# **SSD 6339 St Catherine's School Campus Master Plan**

Prepared with content and advice from SLM Consulting  
by Charing Cross Village and Bronte Beach Precinct Committees

Date Submitted 1.12.2014

TRAFFIC MANAGEMENT AND PARKING

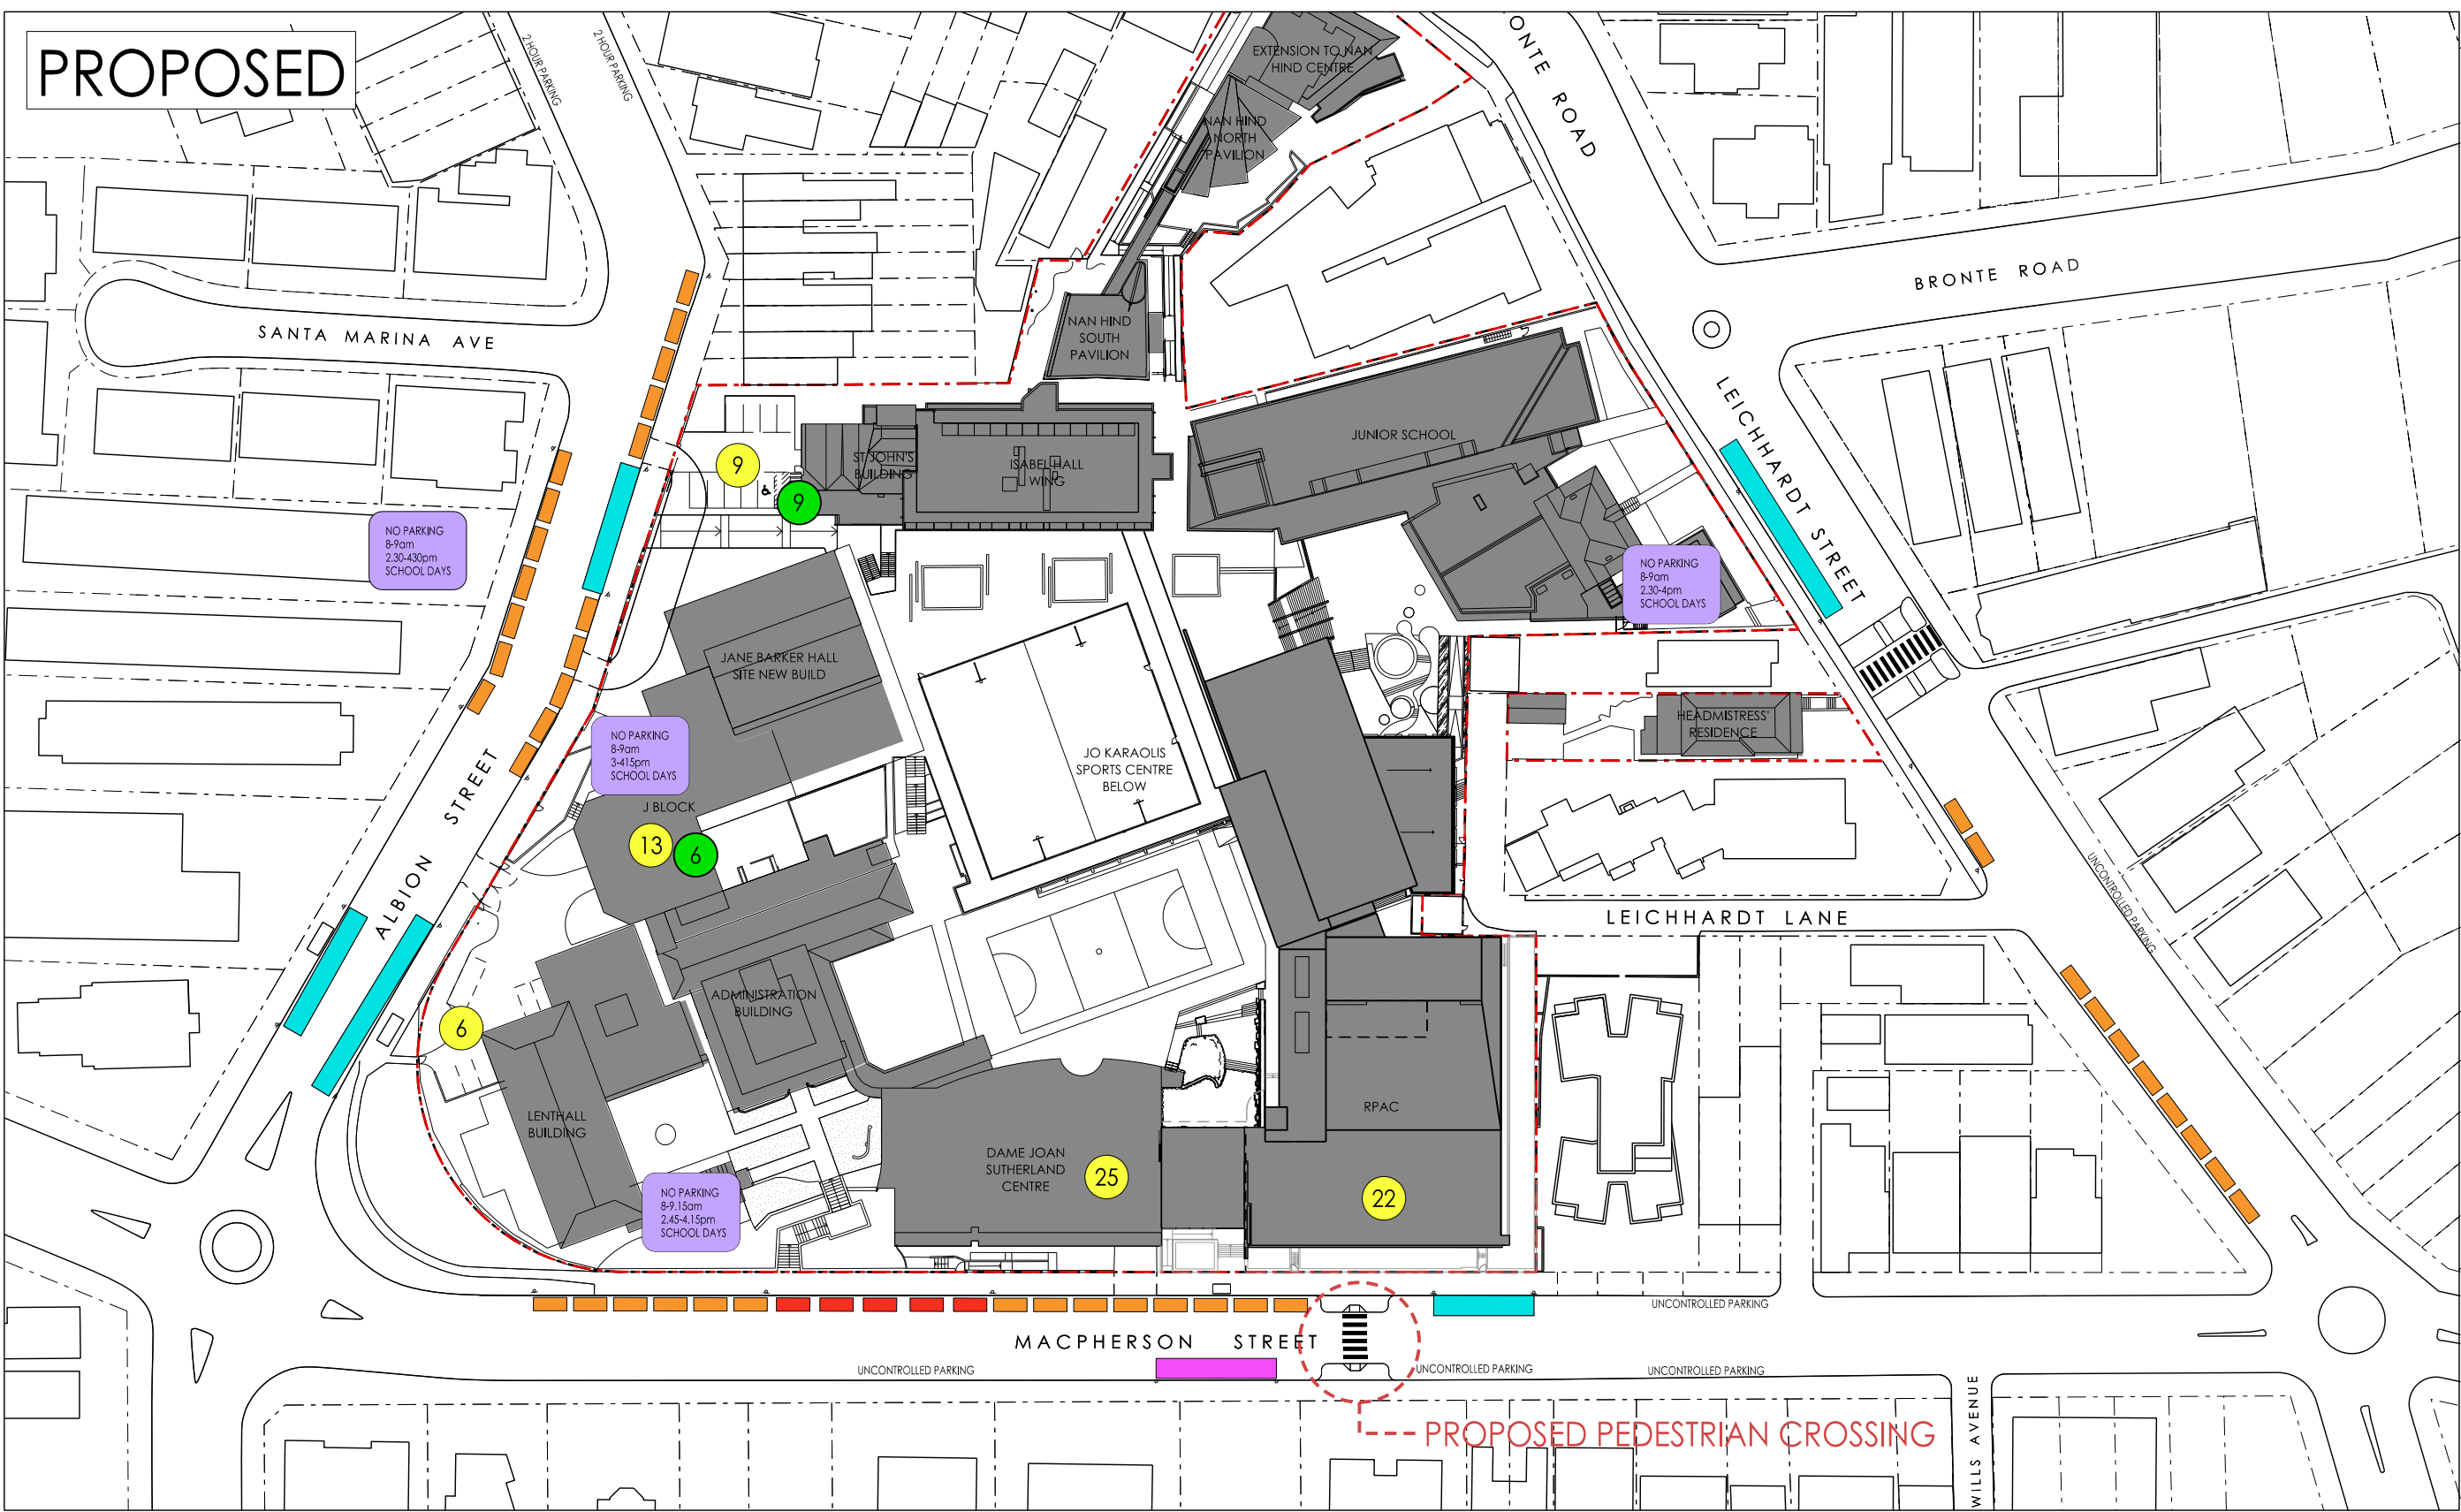
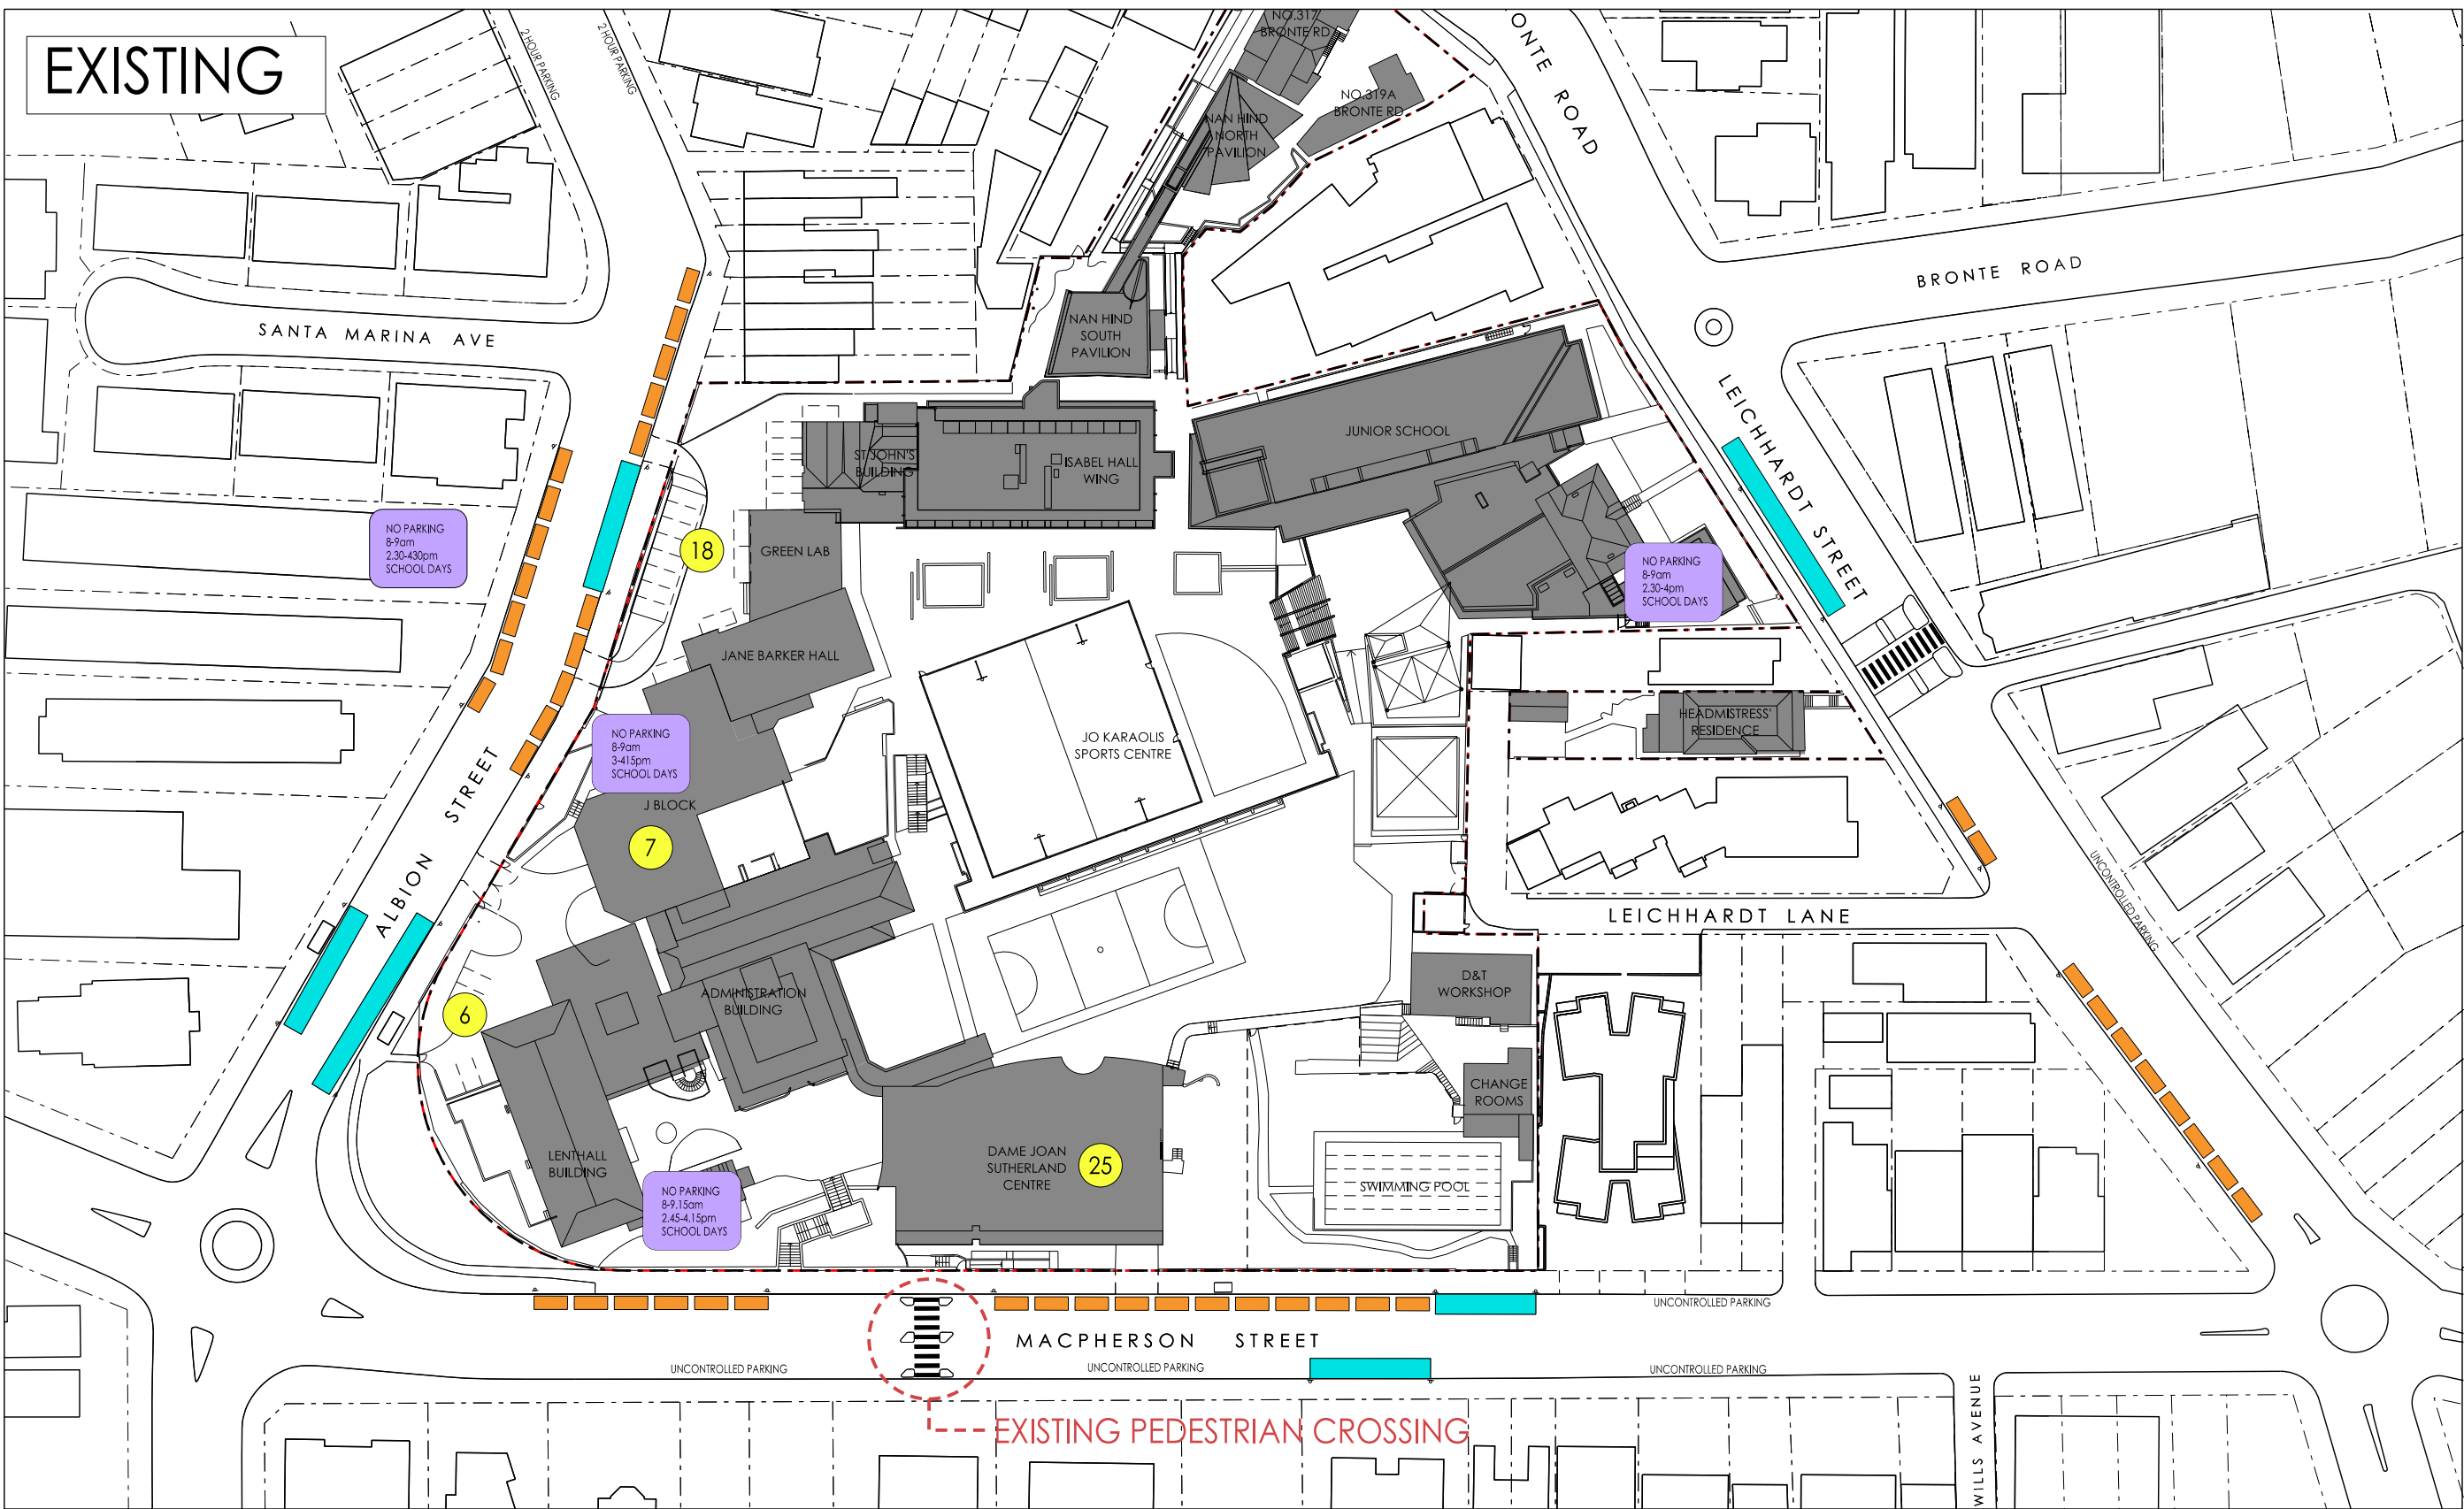
- The Master Plan does not provide for adequate on-site parking for staff members and visitors to the school, nor is there any provision for on-site drop-off and pickup of students

**Recommendation 8:** That the Master Plan be revised to provide adequate on-site parking options to accommodate all staff, daily visitors and licensed Year 11/12 students, and address the increased intensity of use of the school theatres and sports facilities and associated quasi-commercial and non-commercial activities. According to the school's traffic consultant's models, this would require on-site parking for at least 200 vehicles.

The on-site parking provisions by the school both currently and in the Master Plan are manifestly inadequate for the current and proposed user population that choose to travel by car. It is no longer tenable for the school to be treated differently from commercial enterprises in the requirement to provide adequate on-site parking for their users that arrive by car.
